OUT21/2186

**Bobs Farm Sand Mine Project (SSD-6395)
Response to Submissions (RTS)**

Mitchell Isaacs
Chief Knowledge Officer
Department of Planning, Industry and Environment: Water
12 April 2021

Detailed advice to DPIE Planning & Assessment regarding the Bobs Farm Sand Mine Project (SSD-6395) – Response to Submissions

**Figure 7.12 - Hydrogeological Cross Section**

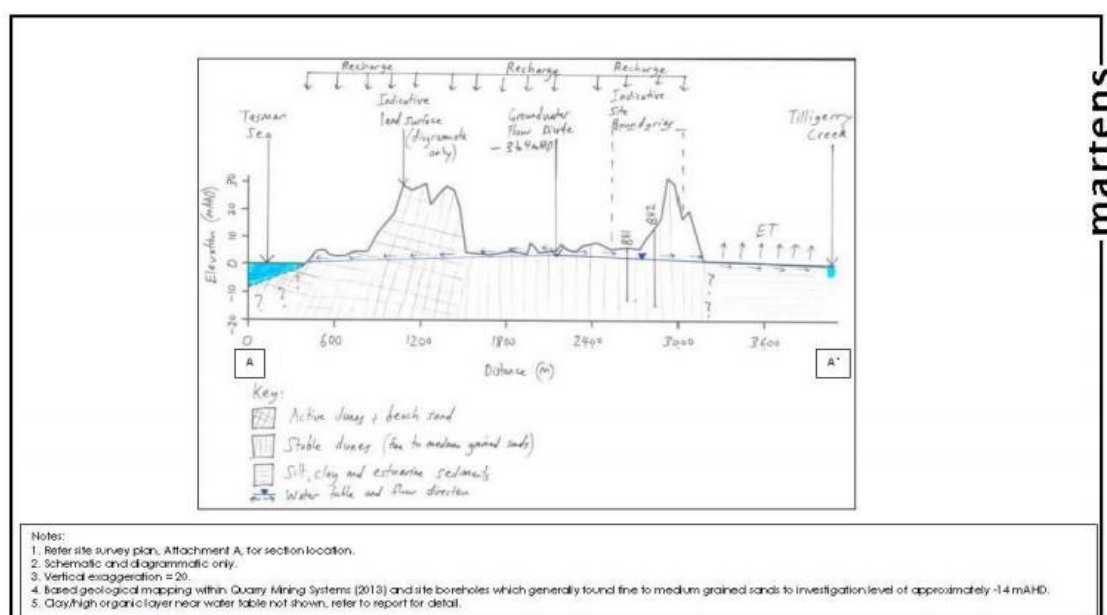
An examination of the lithological profiles shows that the majority of the samples tested for net acidity were taken from light brown and yellow/white sands, marginally above the transition into the underlying grey marine sands. The grey sands that are more likely to contain pyritic material are shown to be present in all lithology logs for Bobs Farm, however sampling depths were mostly above 1 mAHD and therefore are not representative of the marine sands that occur to -15 mAHD which are planned to be mined.

Returning to the current proposal, the acid sulfate soil test holes do not inform on acidity potential from the deep grey marine sands that are proposed to be mined. Bobs Farm acid sulfate soil risk categorisation presented in the RTS is not supported and not consistent with the evidence for the nearby historical RZM dredge operation. There are several adjacent sensitive receptors including an endangered ecological community (EEC), the Hunter Water Corporation North Stockton Catchment Area (Drinking Water Reserve), and the Worimi National Park. Given their proximity and high aquifer permeability rates, these sensitive receptors could be impacted within a few years of operation.

- DPIE Water has significant concerns about this project in its current form. We recommend that the project be modified to limit extraction to a height that maintains at least a 0.7 metre buffer above the groundwater table with the final landform to be a minimum of 1 metre above the groundwater table consistent with other approved projects of the area.

**Figure 4.7 – Wet Mining Schematic (Extract from QMS Stage 3 Report)**

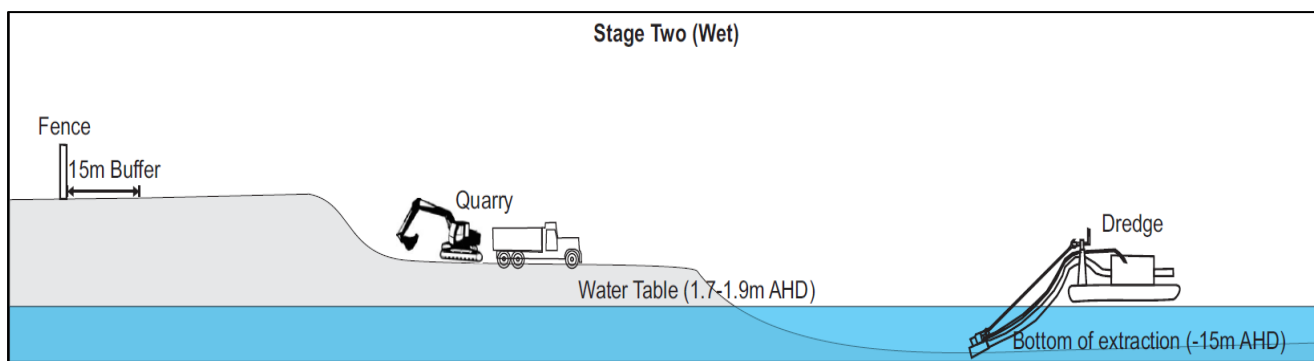
DPIE Water is concerned that the fines rejected back to an oxygenated pond will contain concentrated pyrite, organics and possibly radioactive material. Oxidation of this pyrite leads to the release of metals and the organics and the generation of a sludge at the base of the pond. The pyrite distribution is likely to be random, heterogenous and predominantly dispersed within the deeper grey sands layer that have not been robustly assessed. The Bobs Farm proposal to extract the deeper grey sands, separating the fines and returning the fines to the dredge pond is a substantial water quality risk.
